Project # 1006824

Project Name: R P TINNIN

**Date:** March 4, 2008  
**To:** Jack Cloud, DRB Chair  
**From:** Carol Toffaleti, Planner, Development Review  
**(cc:** Jennifer Jaramillo, Dekker/Perich/Sabatini)  
**Subject:** Project #1006824, 07EPC-40055, 08DRB-70100 - Mountainside YMCA

JACK  
1006824  
AGENDA ITEM #8

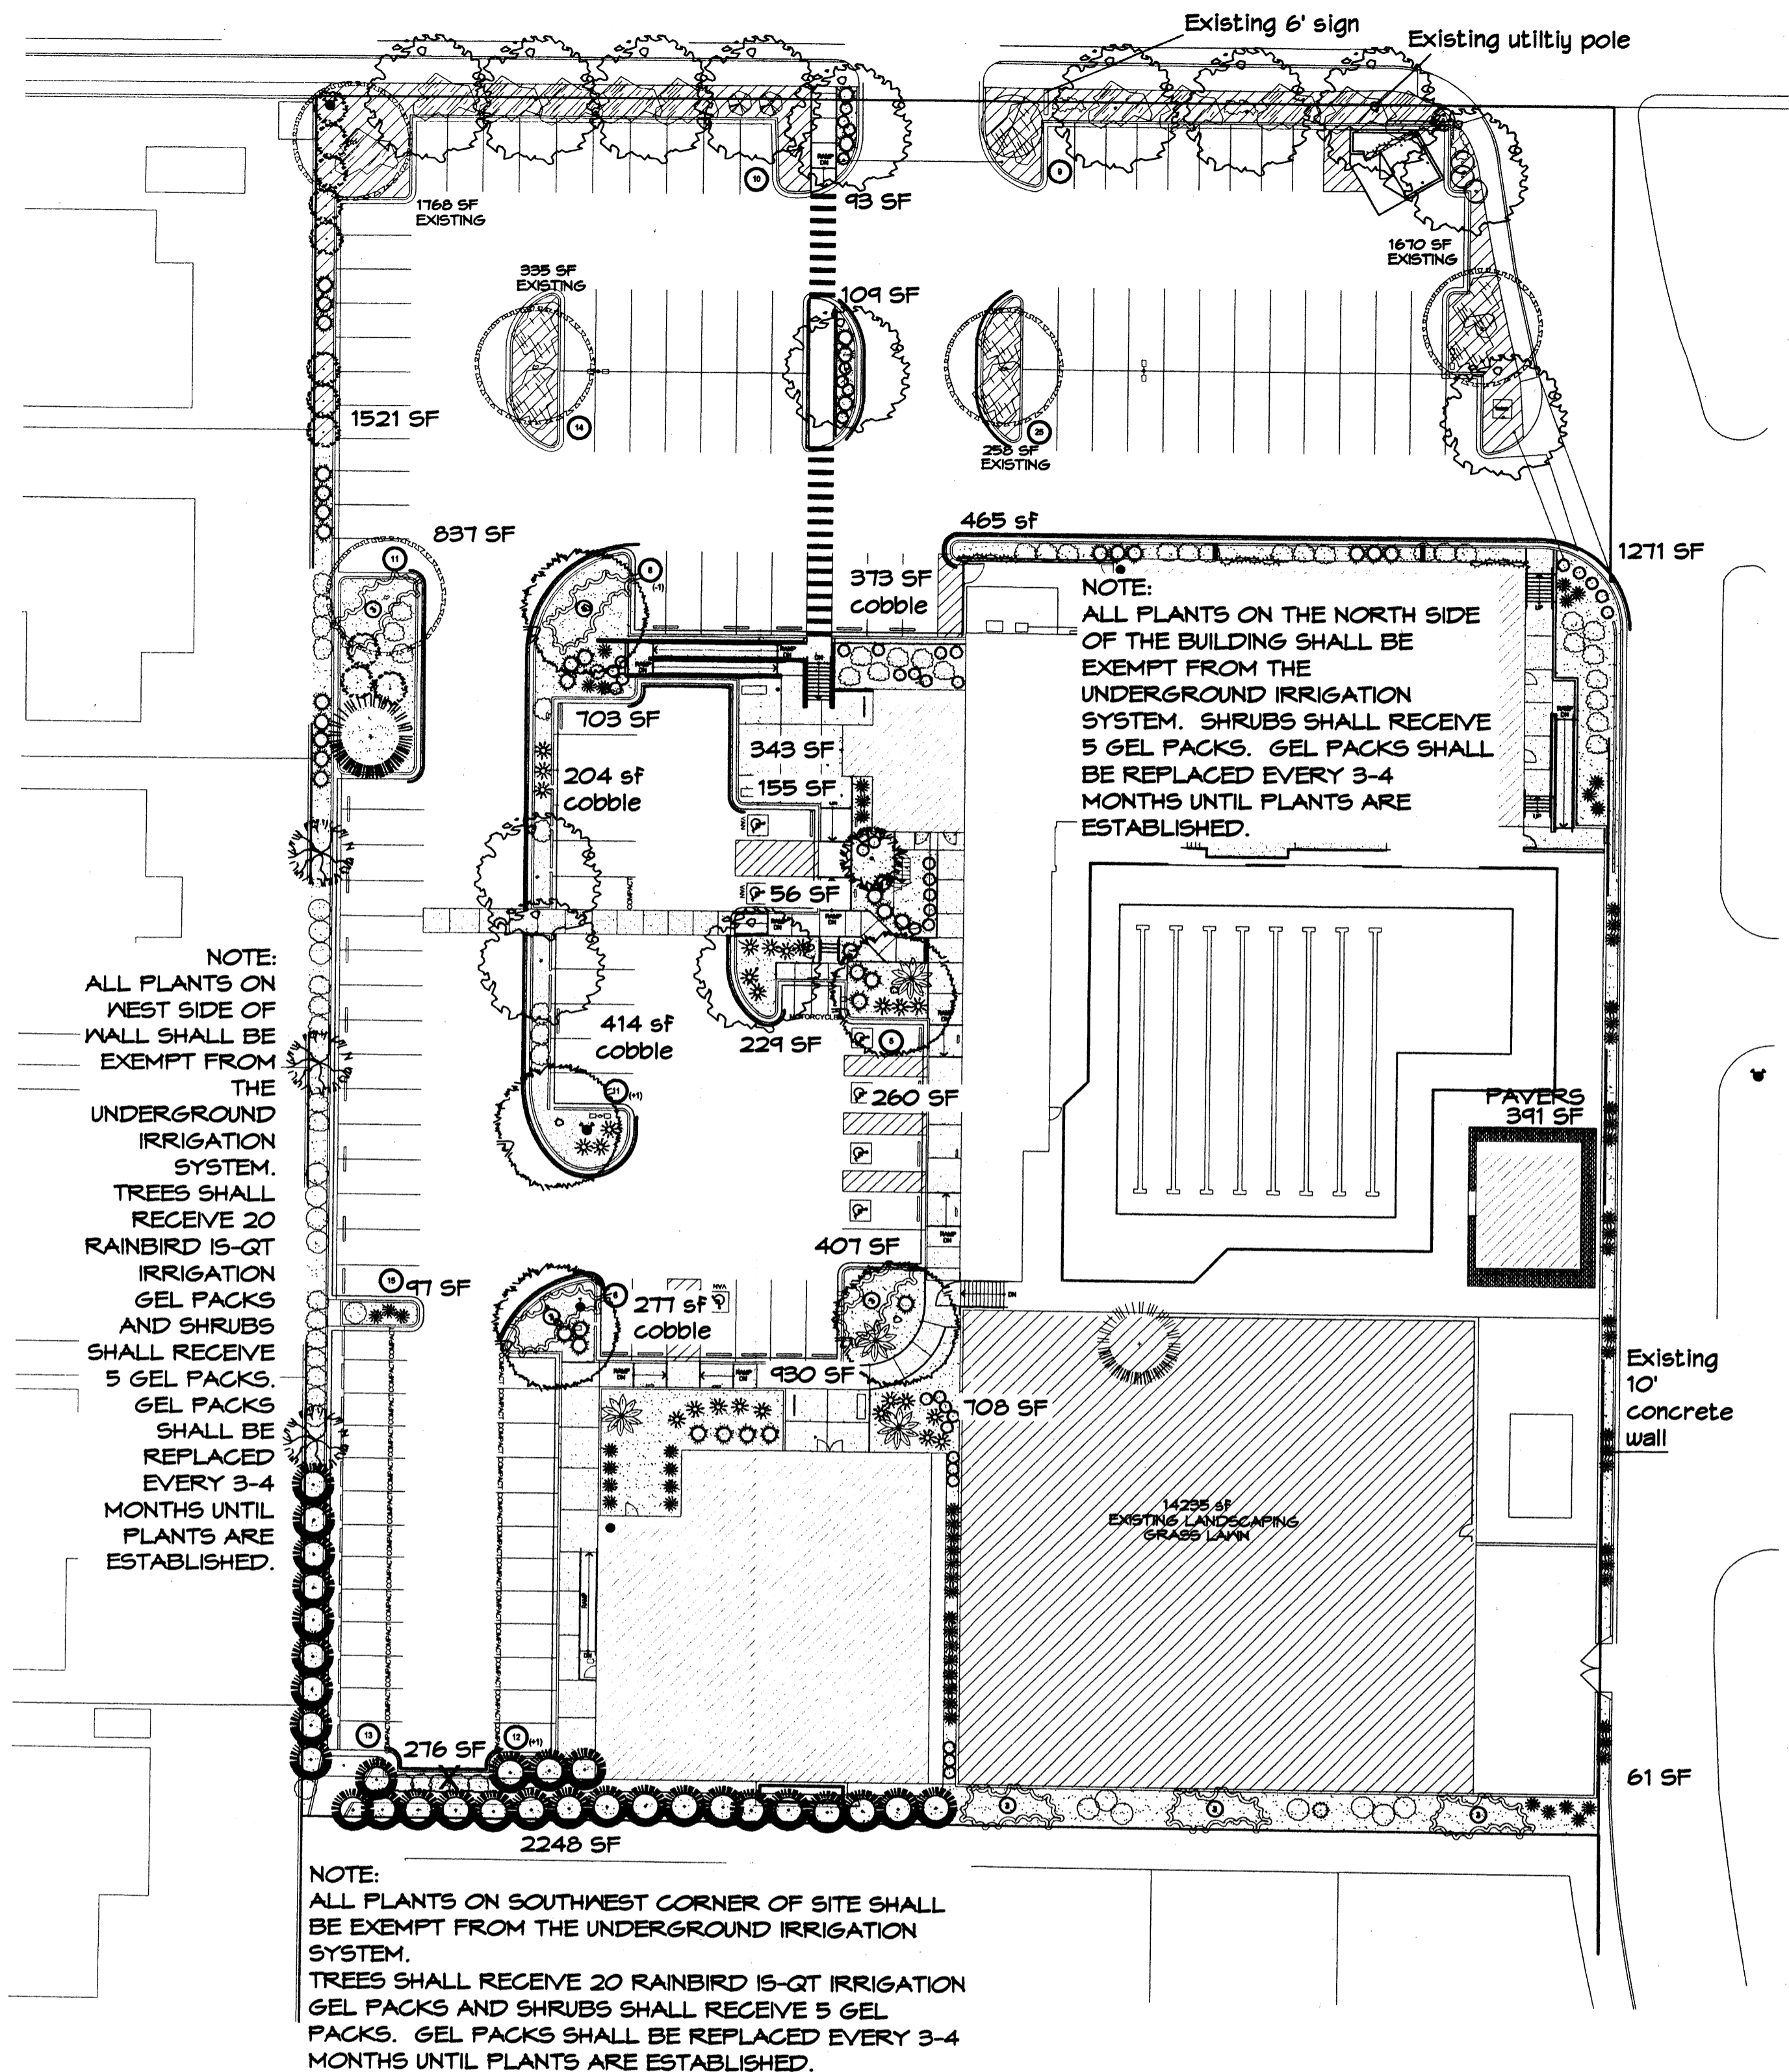
The proposed landscaping along the southwest boundary of the site, where it adjoins 3604 Yosemite Drive, consists of Powis Castle Sage. This species will not provide the solid screening required to protect the residential property from the adjacent parking, because the fence separating the properties is open chain link fencing.

*Staff recommends that the sage be replaced, and/or supplemented, with low water use evergreen plant(s) that reach a height of at least 6'. (Staff also recommends that the symbols used on the landscape plan for Apache Plume and Powis Castle Sage be more distinct from each other.)*

The landscape plan was revised to include English ivy as a screen for the refuse enclosure that was relocated to the northeast corner of the site in response to Condition 9.

*Staff asks that the ivy be moved to the north side of the recycle enclosure, rather than the refuse enclosure, as it is the former that will be visible from Comanche and require screening.*
